Your Ref: OWPC16594
Our Ref: K/33/17/HH 06-11-2017
Please ask for:
Mrs A Gardner

Revised proposal for ancillary accommodation. Resubmission of K/10/17/HH
Fynings Middle Way Kingston Gorse

Drawing: LOCATION / BLOCK PLANS

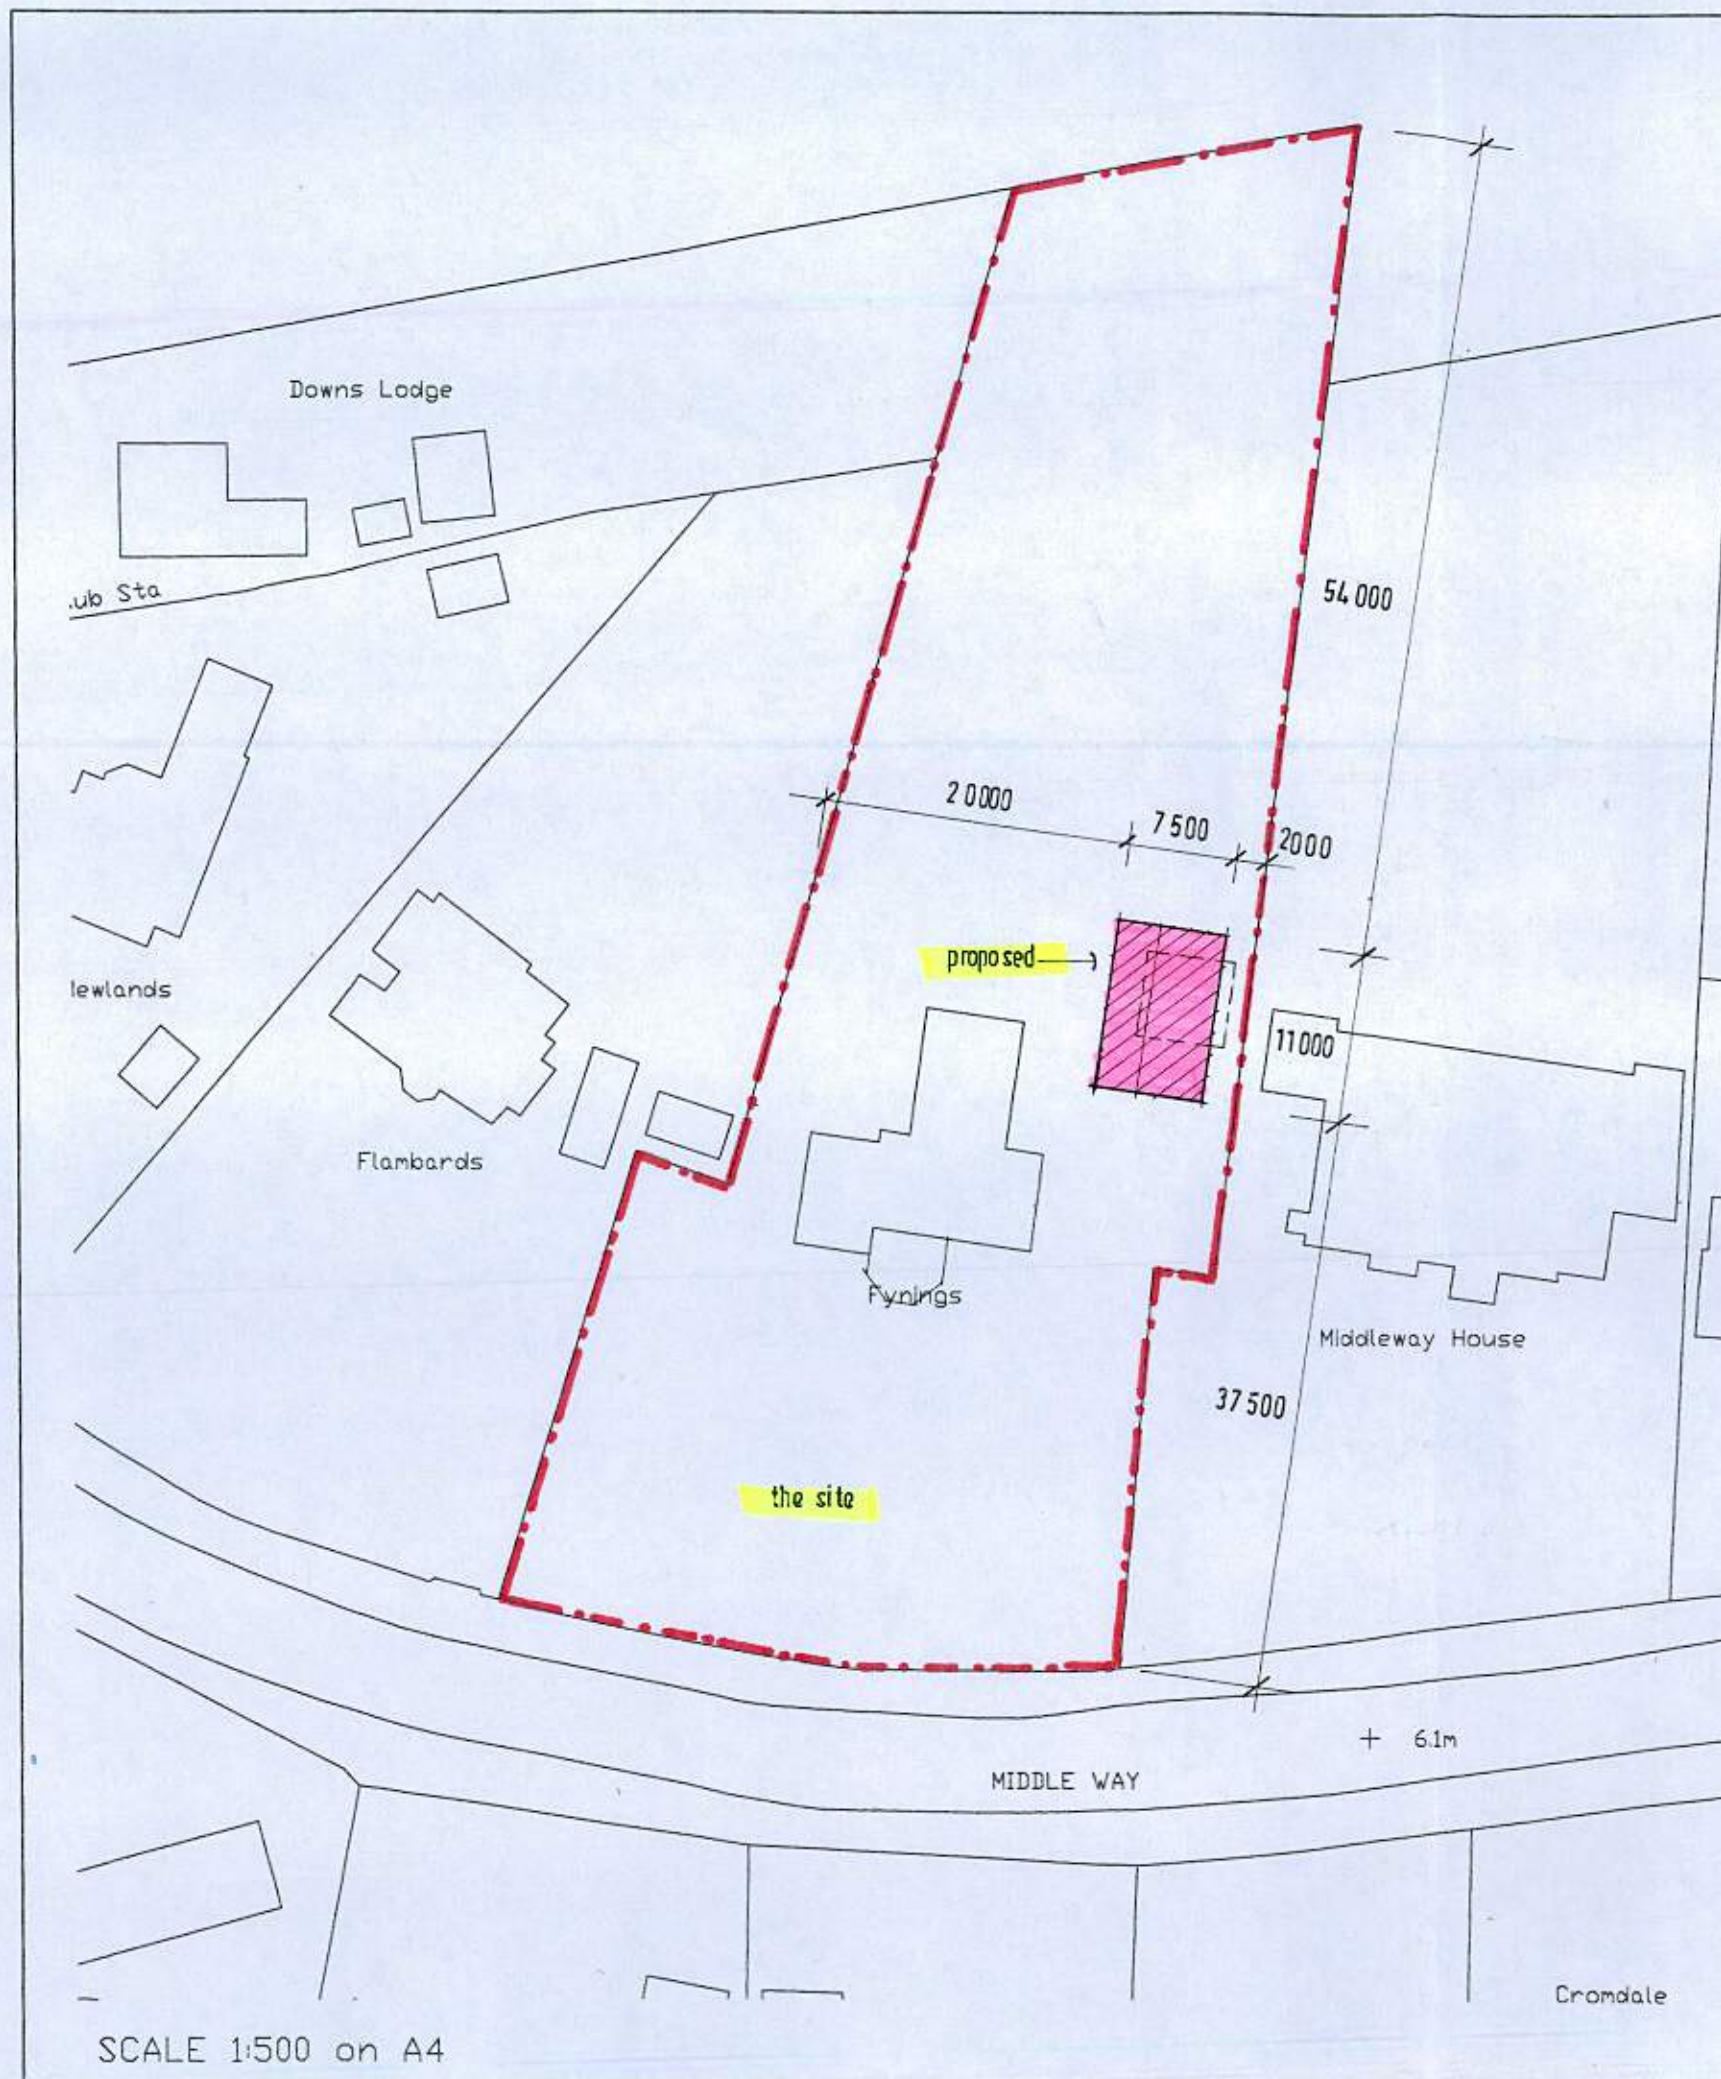
Retains the position of the building as shown in the application at 3.0 meters in front of the building line of the existing garage but reduce it's bulk and mass by the substitution of a flat roof.

1. Retain the roof as shown on the application but move it back to the line of the existing garage as proposed on the previous approval for a two storey building.

17/4445/4

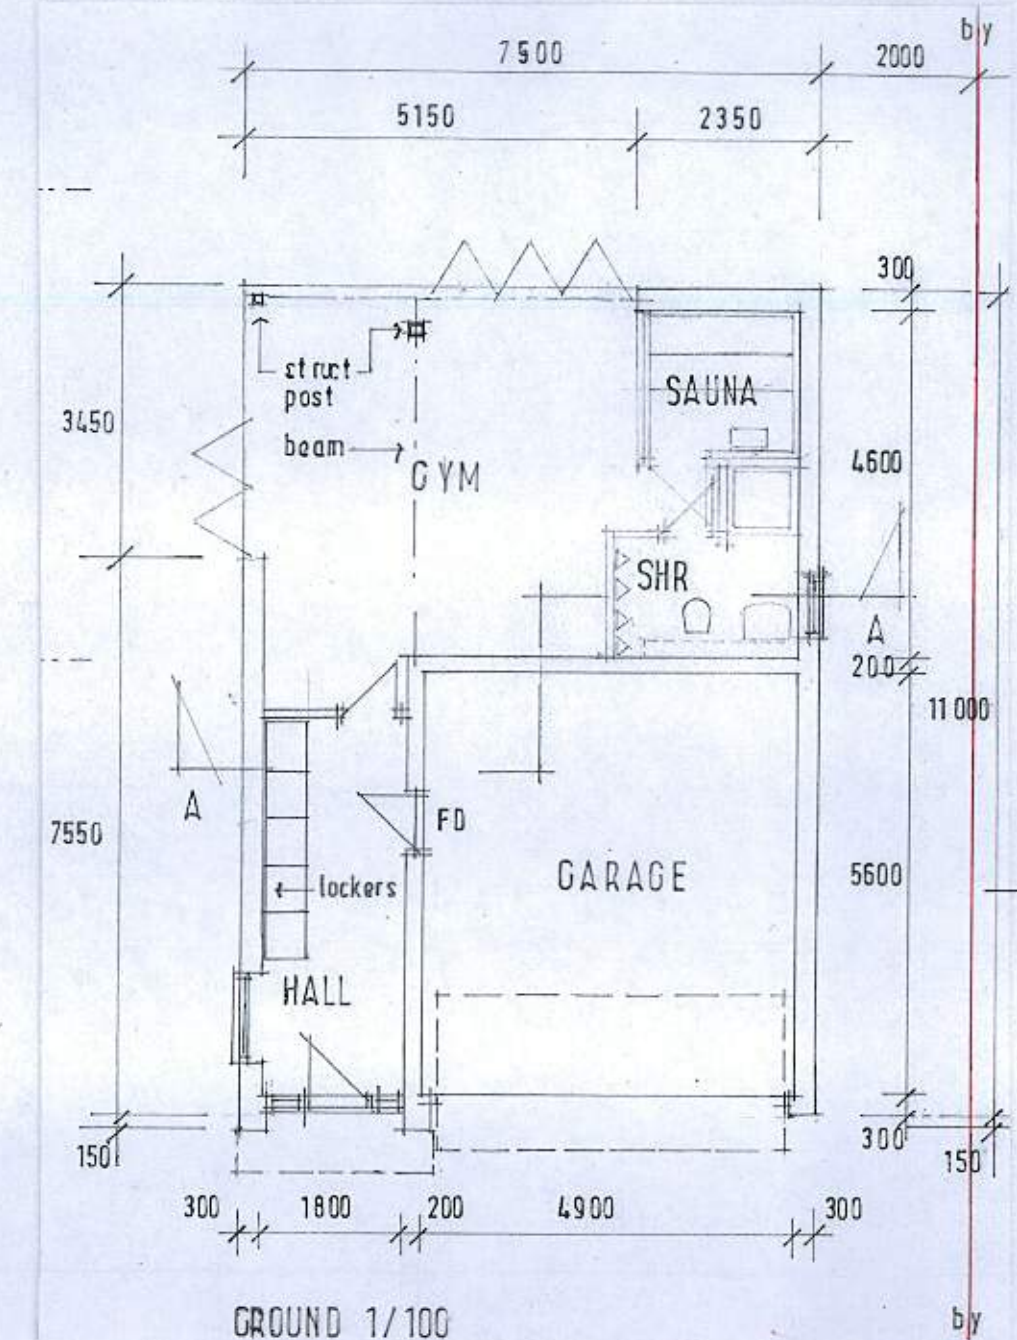
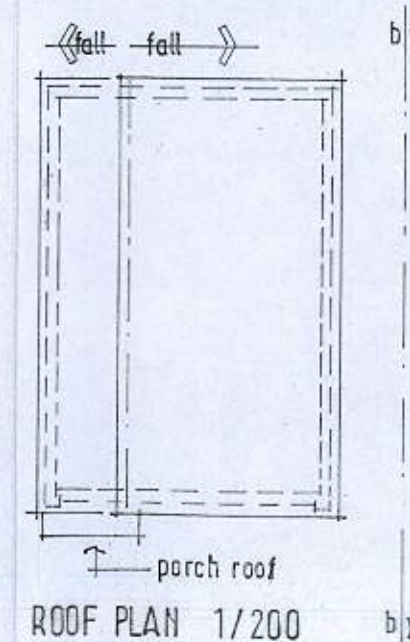
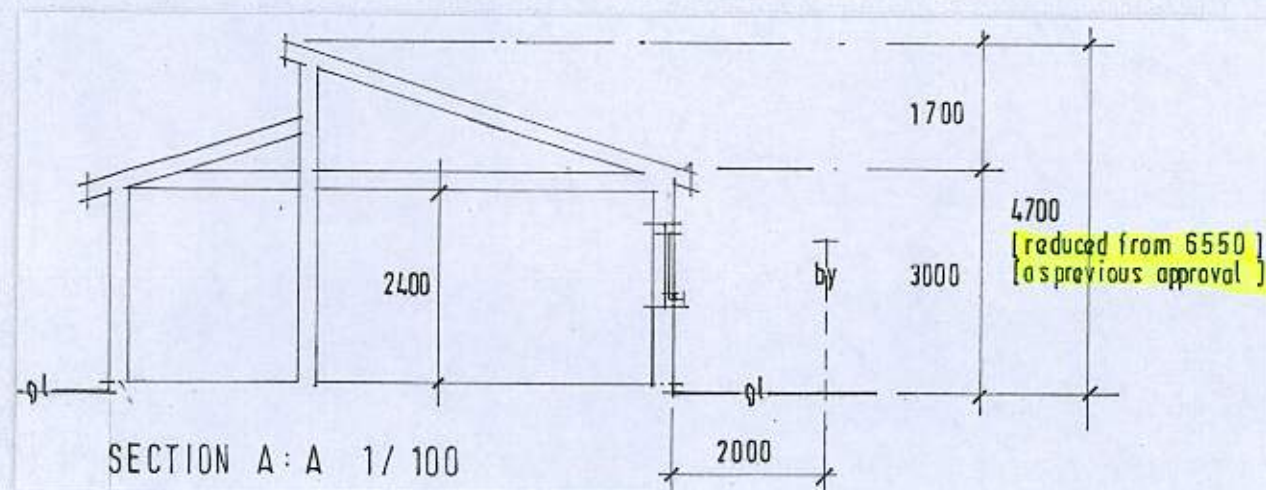
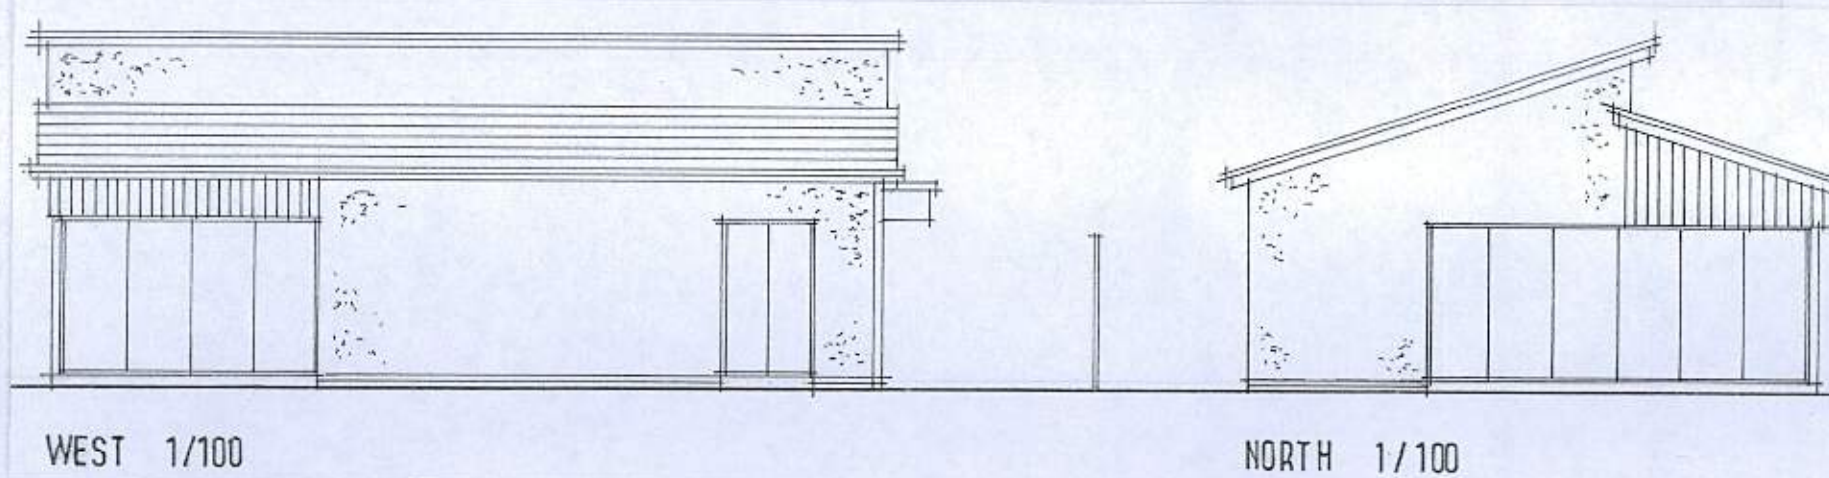
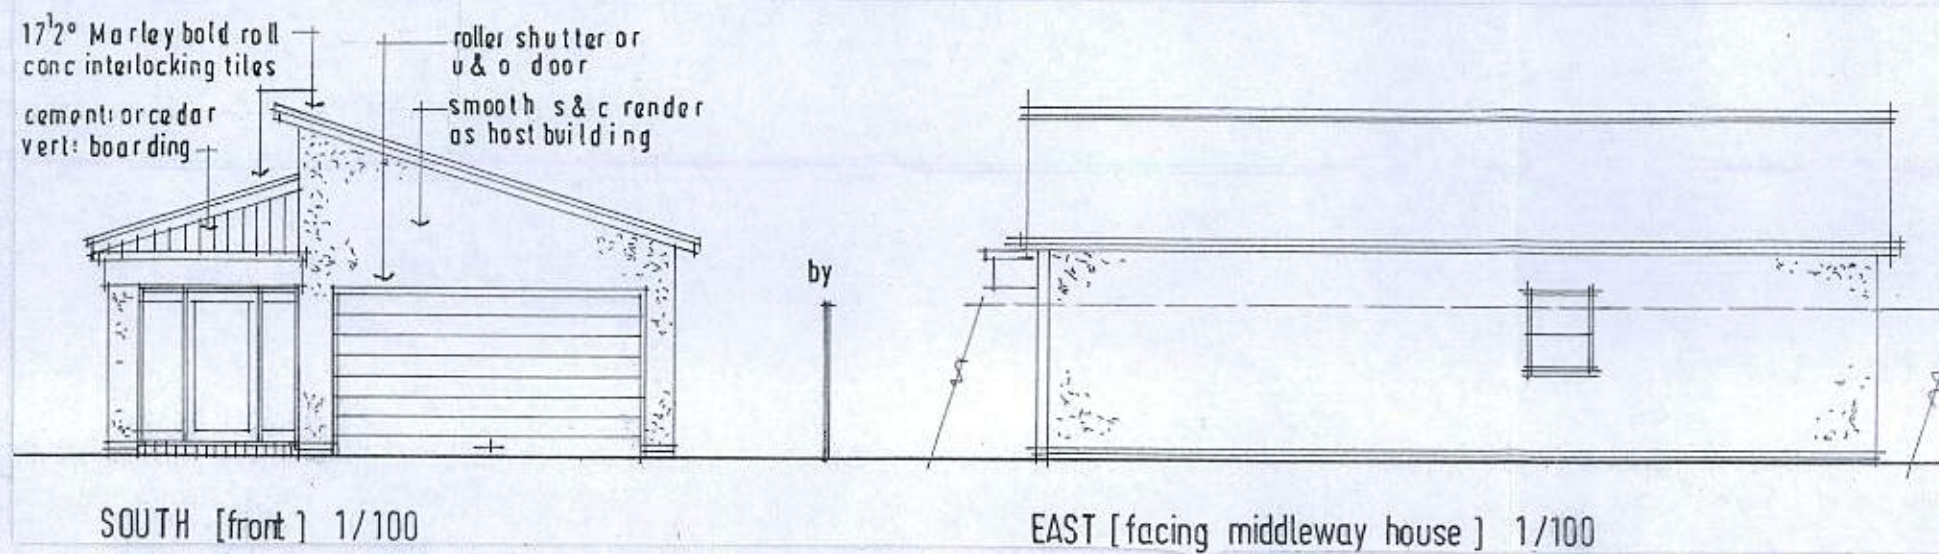
Although now single storey, the revised location is now positioned directly in front of habitable rooms to the property to the east, Middleway House. The building has a mono-pitched roof 4.7 meters in height and this is higher than the existing garage and will have an impact on the residential amenities especially the living spaces on the western side of Middleway House. In order to preserve the residential amenity of Middleway House there are two options.
